Preliminary Acceptance Punchlist
El Paso County – Department of Public Works - Stormwater Section

Project Name:	Retreat at TimberRidge F2
EDARP Filing Number(s):	SF2121 CON2229
ESQCP Number:	ESQ2224
Attendees:	DPW SW: Ben Jones, Glenn Reese, Mikayla Hartford, Dylan Finley DPW Dev Services: David Parkerson Developer: Adam Doyle
Date of Walk-Thru:	05/23/2023
Walk-Thru Number:	1

DESIGNED BY	PRA	SCALE	DATE
DRAWN BY	PRA	(H) 1" = 100'	SHEET 3 OF 24
CHECKED BY		(V) 1" = N/A	JOB NO. 1185.20

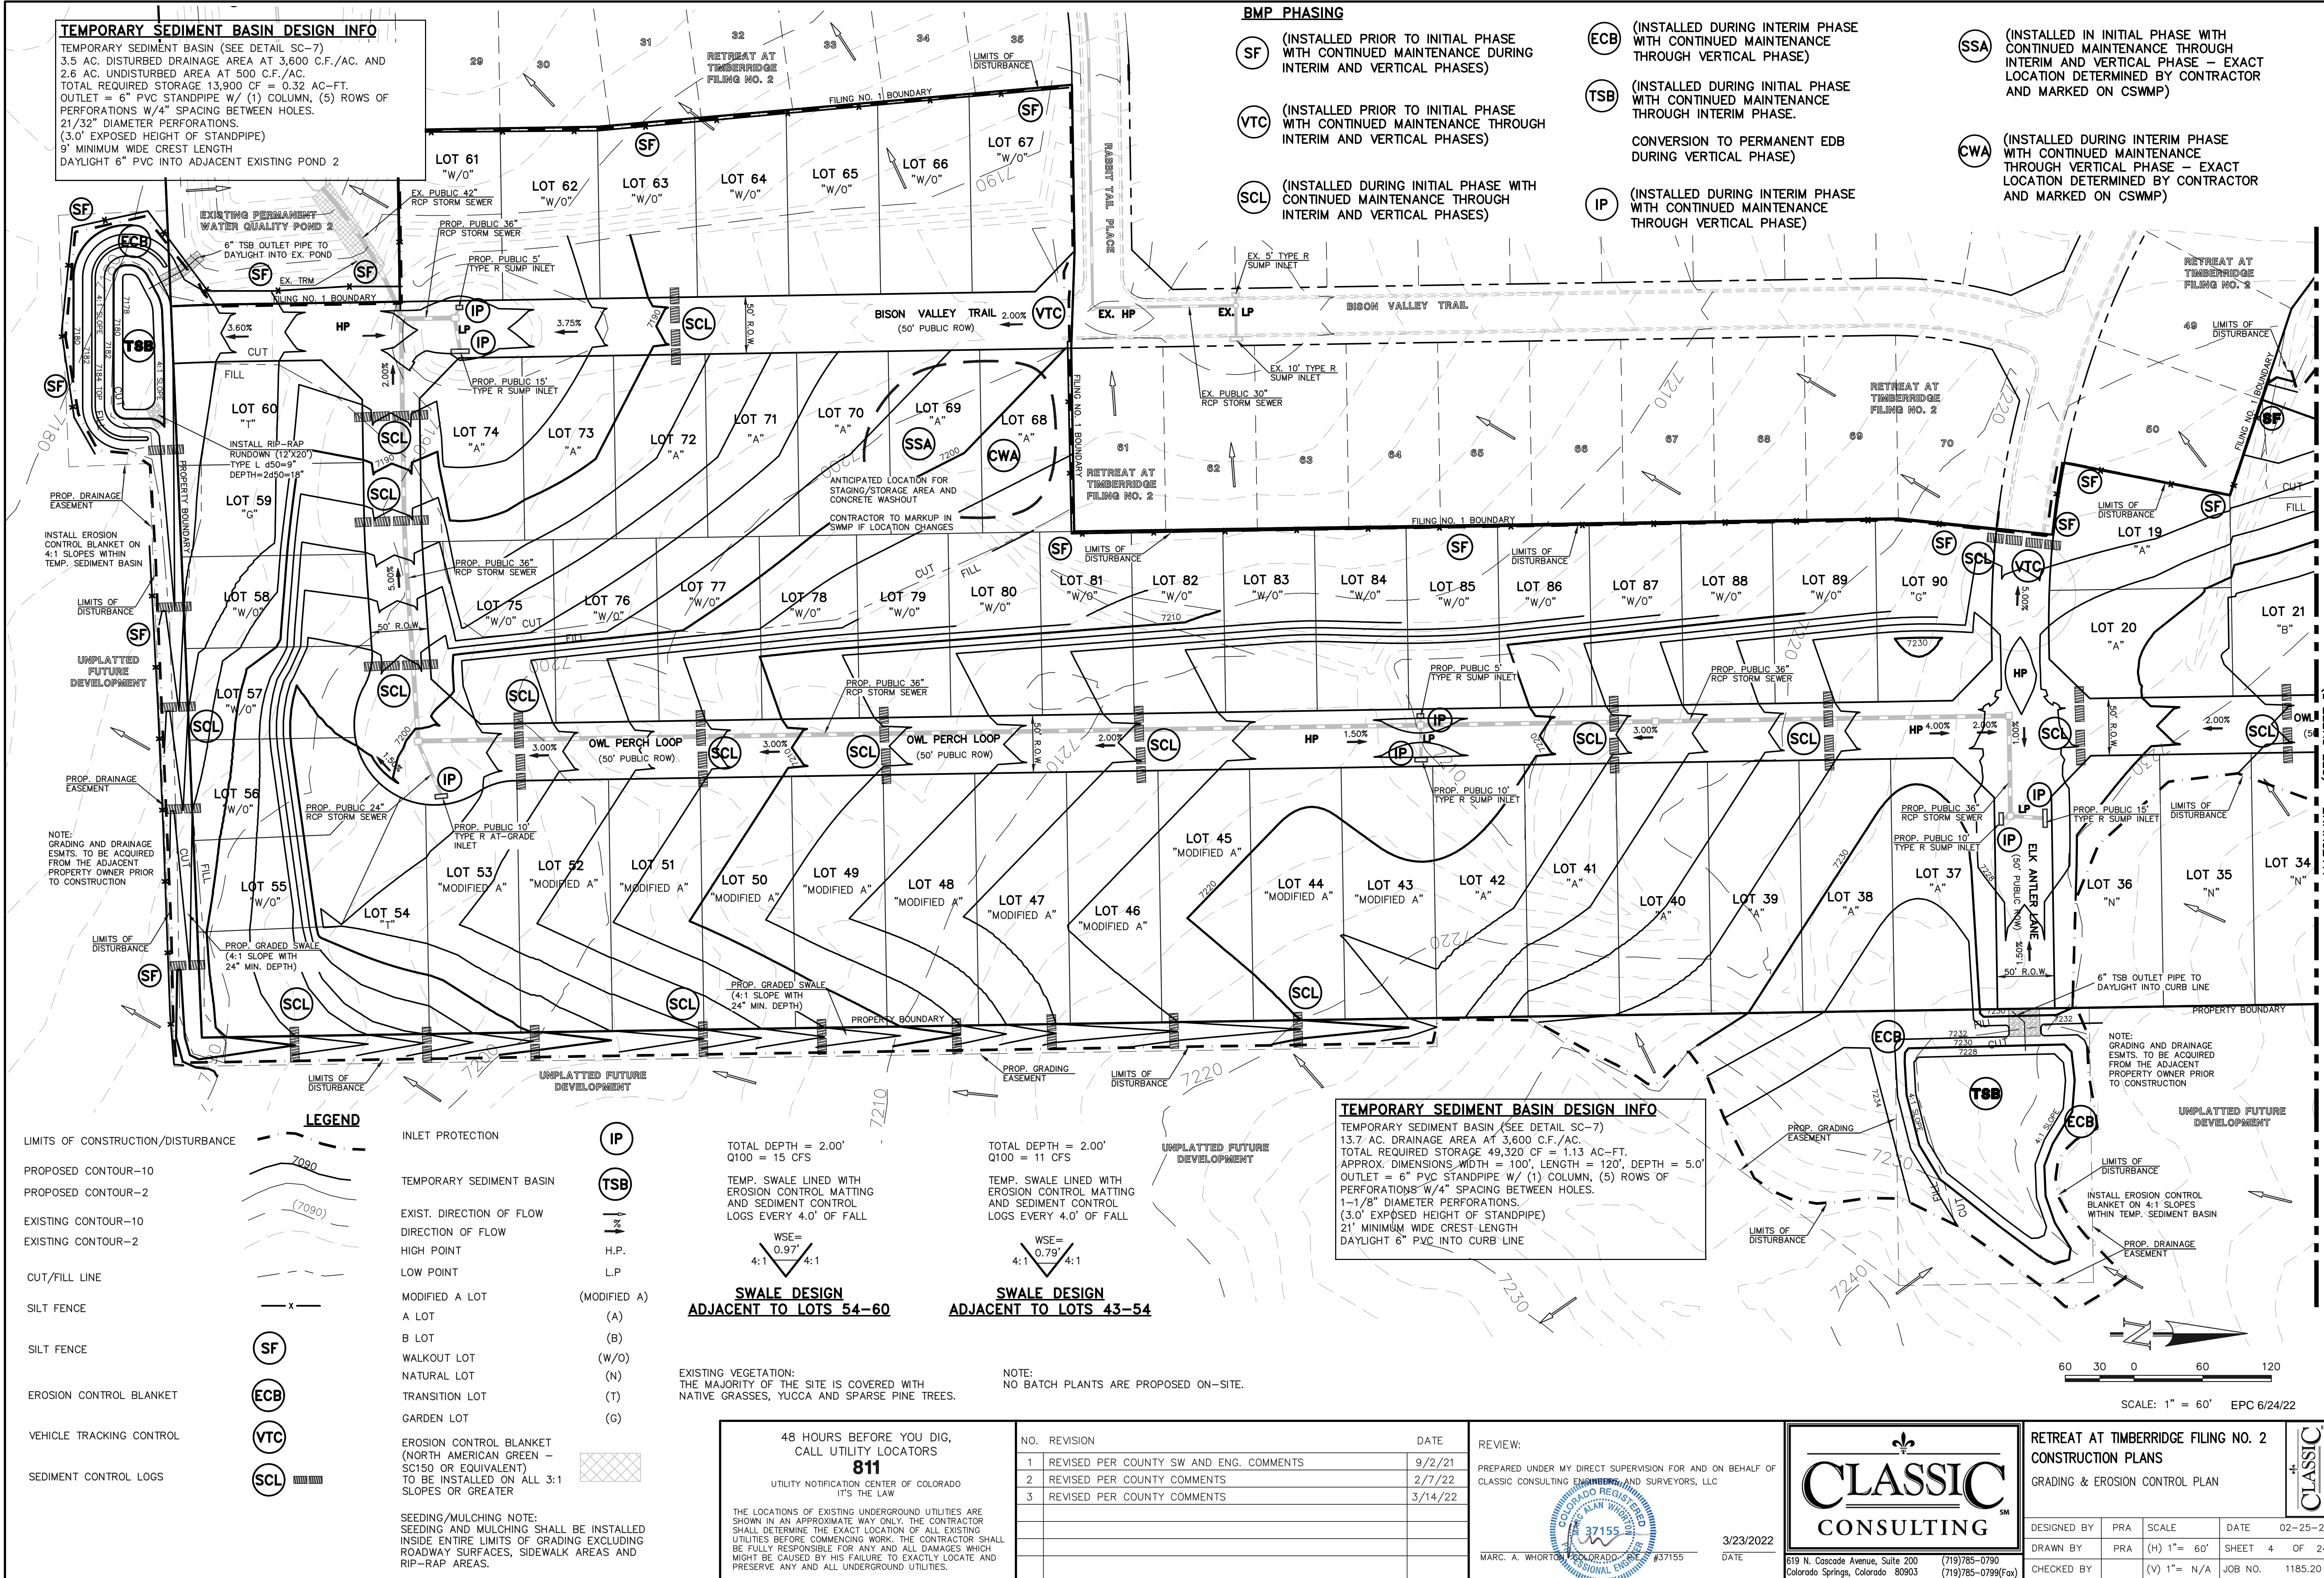
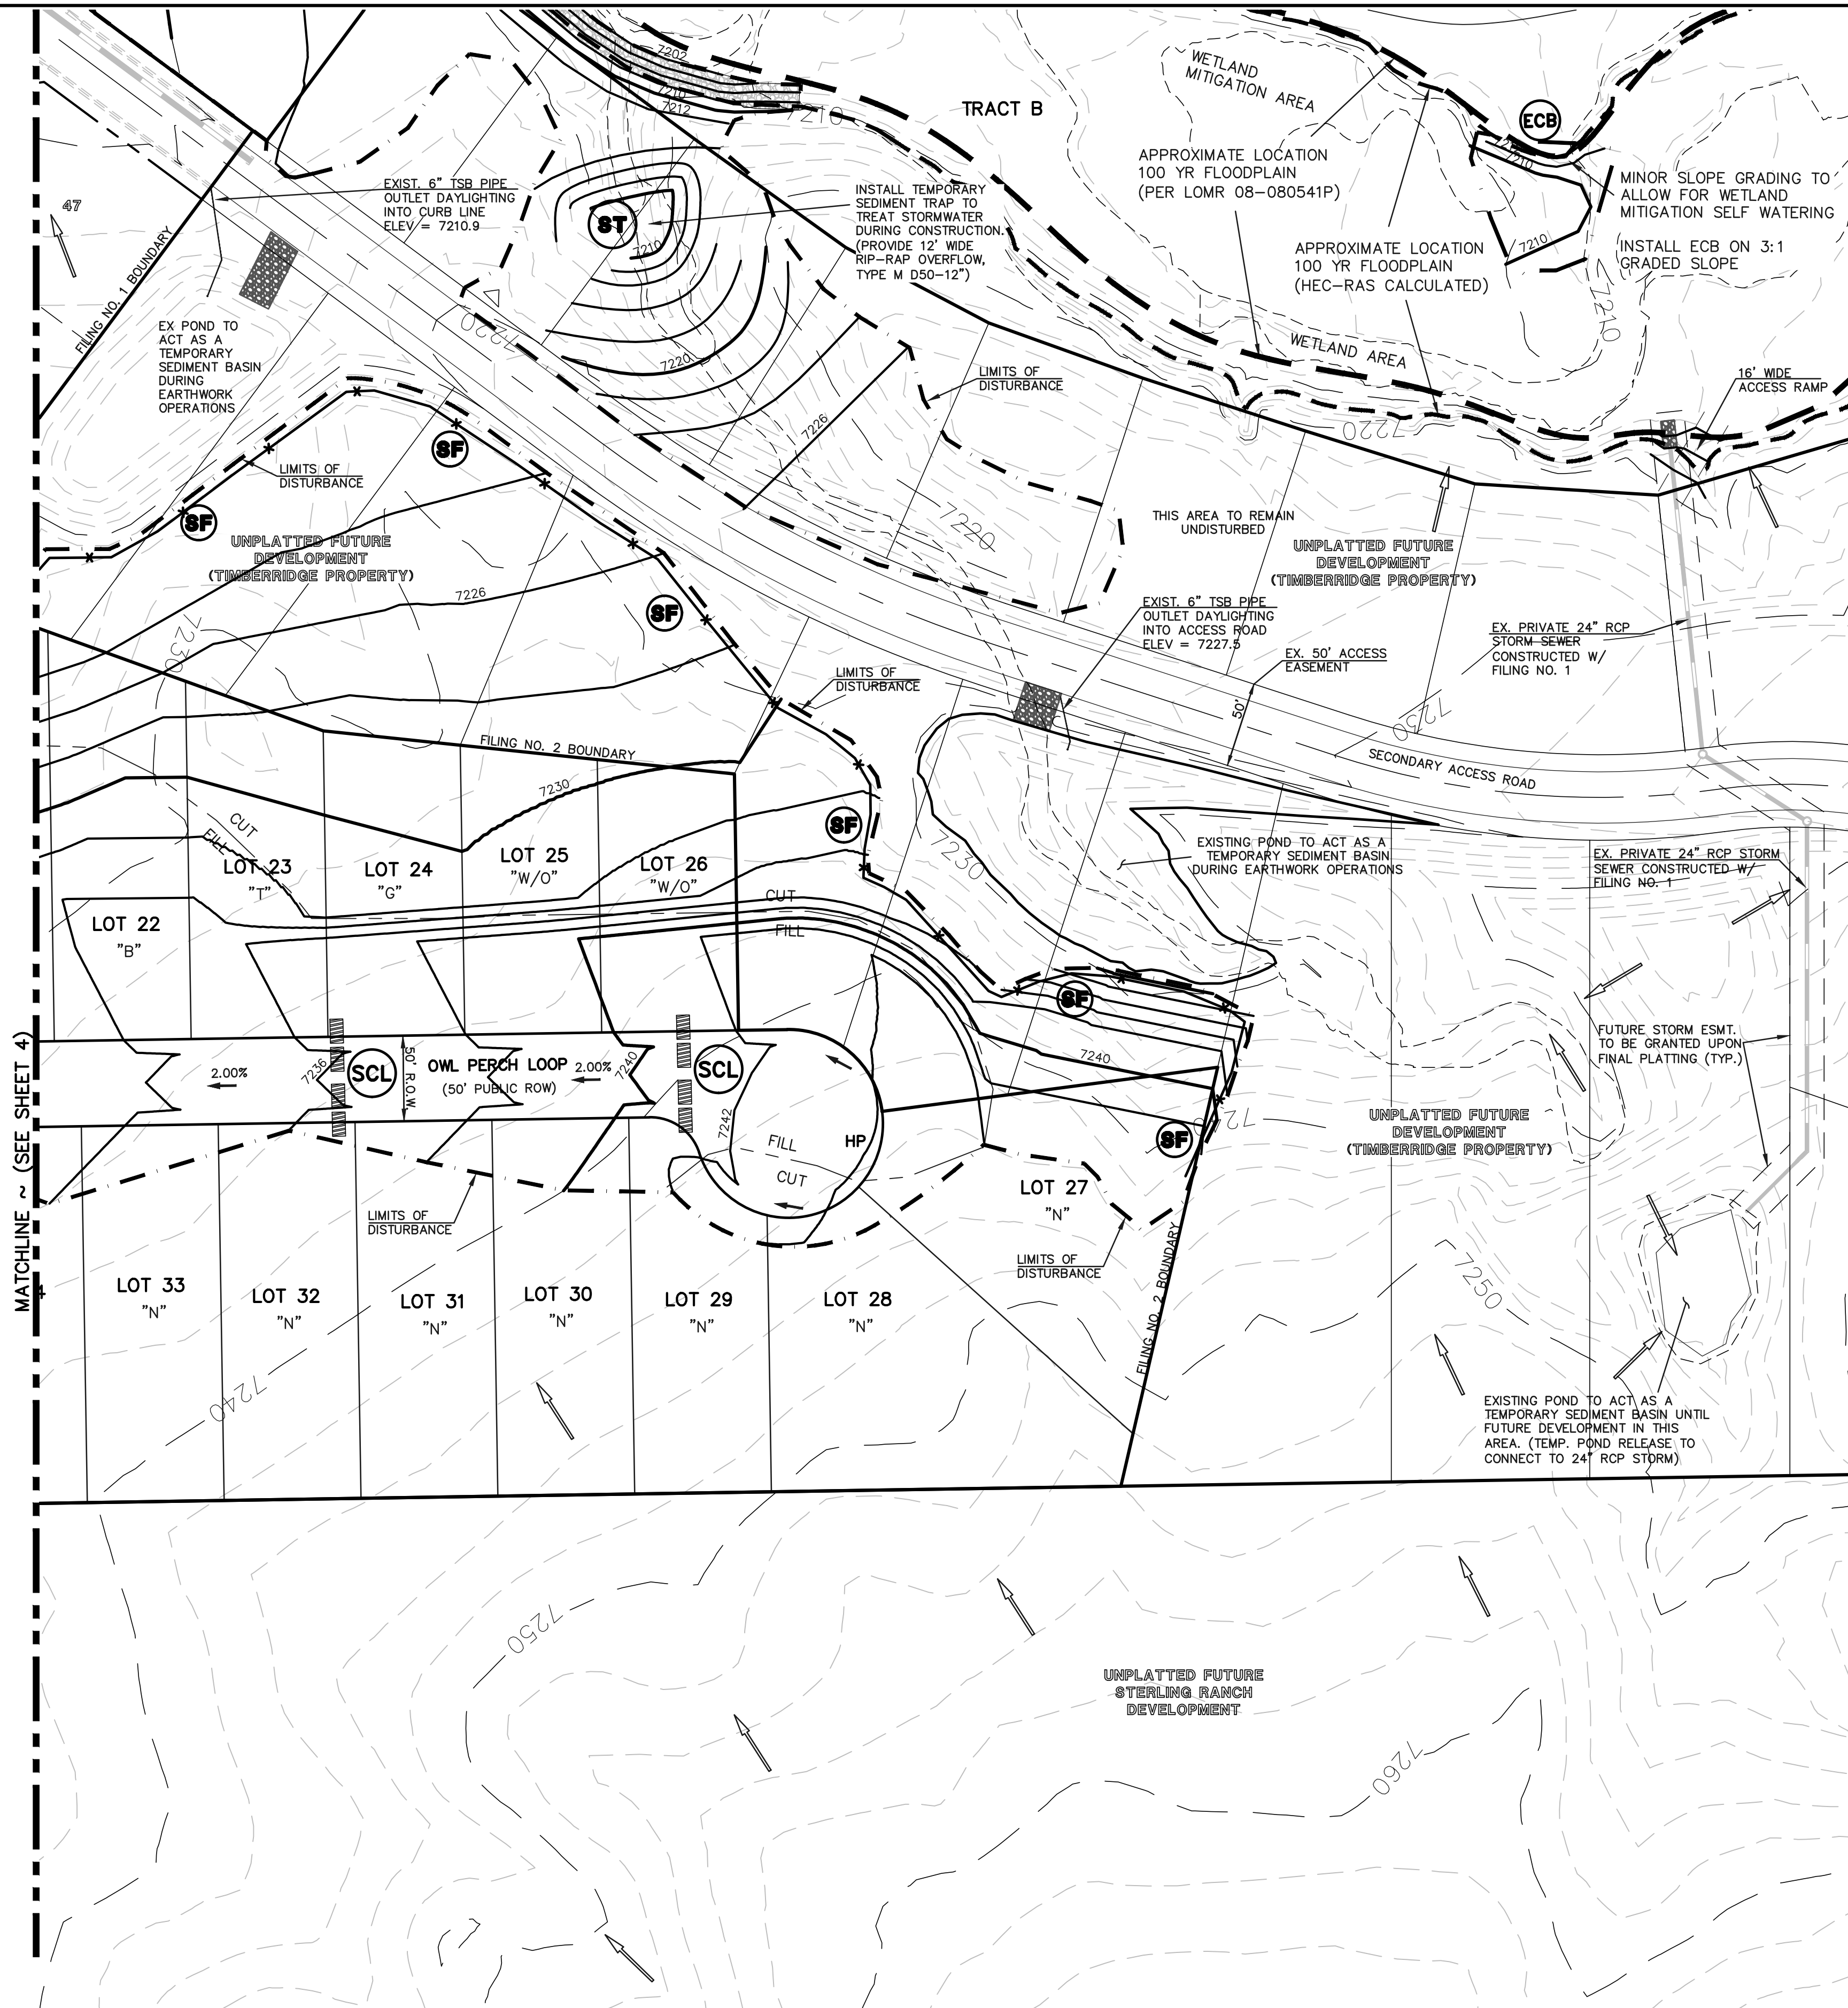
- Significant erosion at outlet of culvert lot 10 where the Temporary Sediment Basin is shown on plans (Page 3 of CD's). Reference Photo 6.
- Regrade ditch at Lot 10 (8872 Falcon Nest Court) to promote positive drainage. Currently standing water in ditch. Reference Photo 11
